Approval of details reserved by condition imposed under ref APP/C3810/W/19/3227374 (CM/16/18/PL) relating to Condition Nos 3 - Construction & Environmental Management Plan, 4 - tree protection & retention and 5 - surface water drainage.

Bairds Farm Shop, Field Rear Of Crookthorn Lane Climping BN17 5SN

Arun District Council have decided to **REFUSE details reserved by condition for the following reasons:**

| DWG NO<br>003                                           | REVISION<br>P5 |                  |                                                        |                                                   |

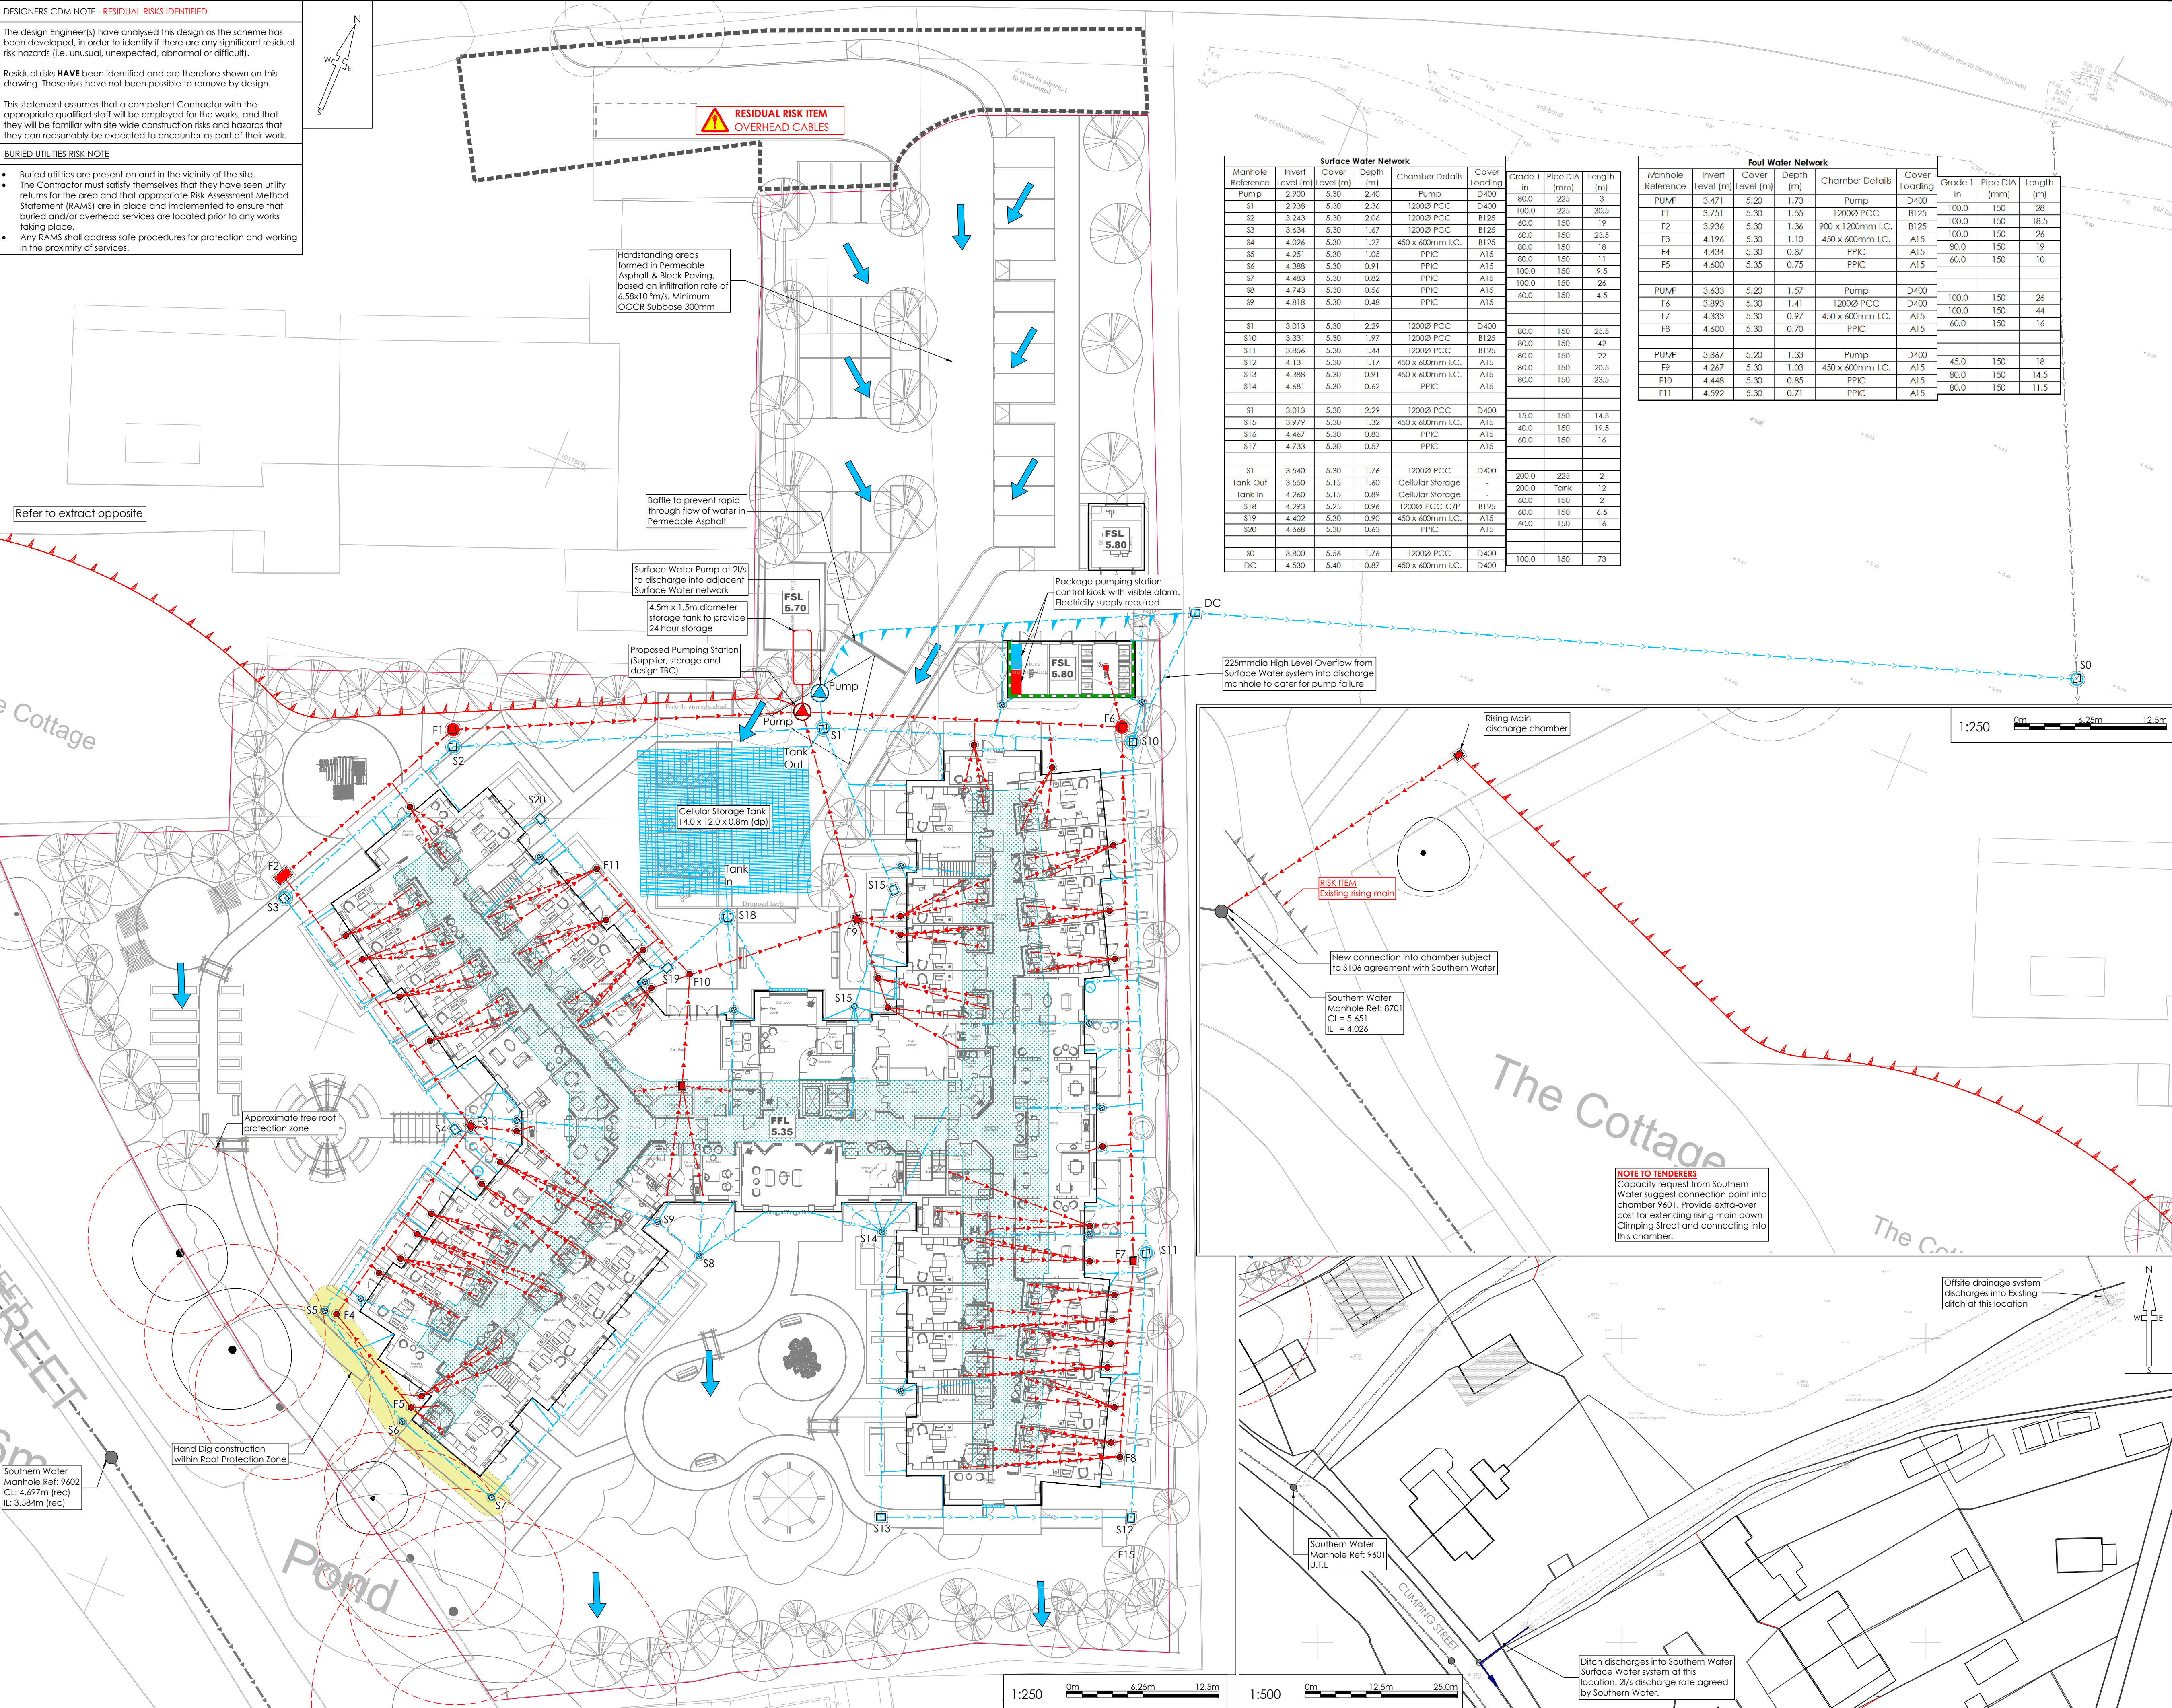
The details submitted are not adequate to demonstrate that the site can be satisfactorily drained. The scheme should be redesigned to avoid a pumped solution.
